**Project# 1008060**

09DRB-70344 VACATION OF PUBLIC UTILITY EASEMENT  
09DRB-70345 MINOR - PRELIMINARY/ FINAL PLAT APPROVAL

CITY OF ALBUQUERQUE  
PLANNING DEPARTMENT  
DEVELOPMENT REVIEW BOARD

SURV-TEK INC agent(s) for 6301 UPTOWN LLC request(s) the referenced/above action(s) for all or a portion of Lot(s) A-2-B-1 & B-1-A, **DALE J BELLAMAH'S JEANNEDALE UNIT 5**, zoned SU-3/ MIXED USE-UPT, located on the north side of UPTOWN BLVD NE between SAN PEDRO DR NE and AMERICA'S PKWY NE containing approximately 4.4842 acre(s). (H-18)

LOT 7-A-1  
DALE J. BELLAMAH'S JEANNEDALE UNIT 5  
FILED 9-11-1990, IN VOL. 90C, FOLIO 220

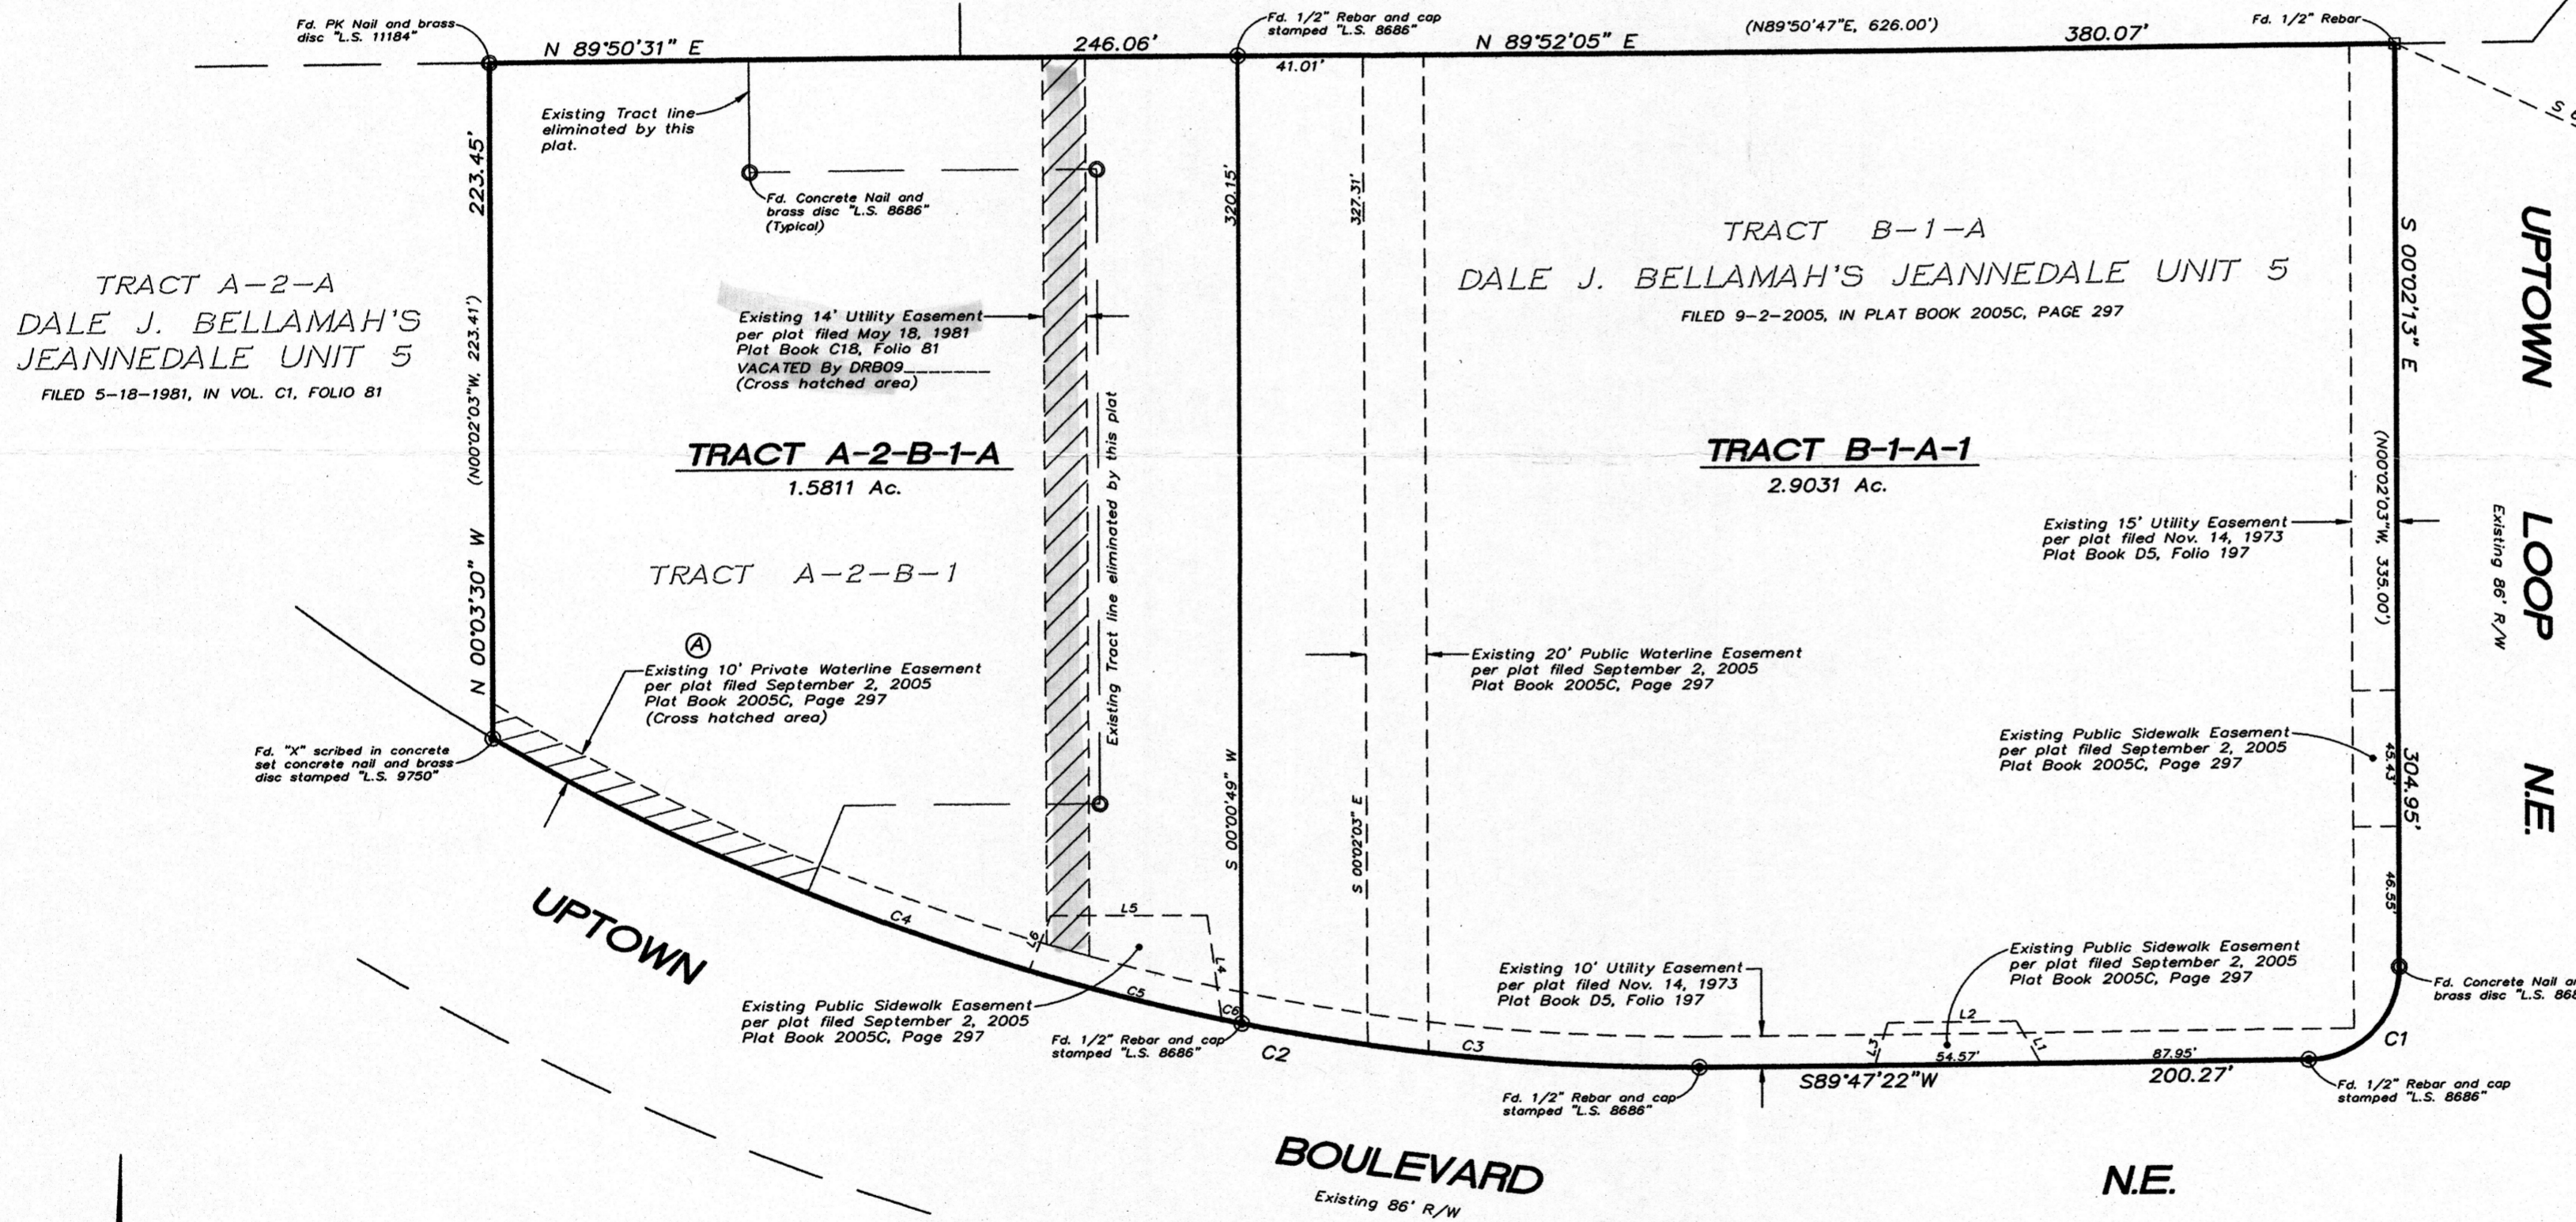
**Vacation of a Public Utility Easement:** PNM will not vacate the easement it supports existing underground facilities.

Concerning the subject case number(s), Qwest cannot comment on the vacation of the public utility easement(s) as submitted; Qwest has existing buried facilities in this area which provides service to addresses 6301 and 6201. Qwest will request the developer to call for locates before the engineer approves of the vacation. If the utilities are found to be within the PUE Qwest will relocate if payment is received for the relocation. Prior to any final plat approval, we will need a copy for review. If specific information is required concerning the requested easement vacation, please contact Richard Redman at 245-6098.

No objection to vacation request.  
Provide an exhibit showing the location of sidewalk and defining the distance from face of curb to the property line. Right of way dedication may be required.

This is acceptable to PNM. Thank you for making these adjustments.

Per your request we have had the line spotted and located the existing transformer. I have created a new public utility easement to cover said infrastructure (see attached). Please let me know if this is agreeable to you as soon as possible so that I may get corrected copies to DRB for tomorrow mornings hearing.
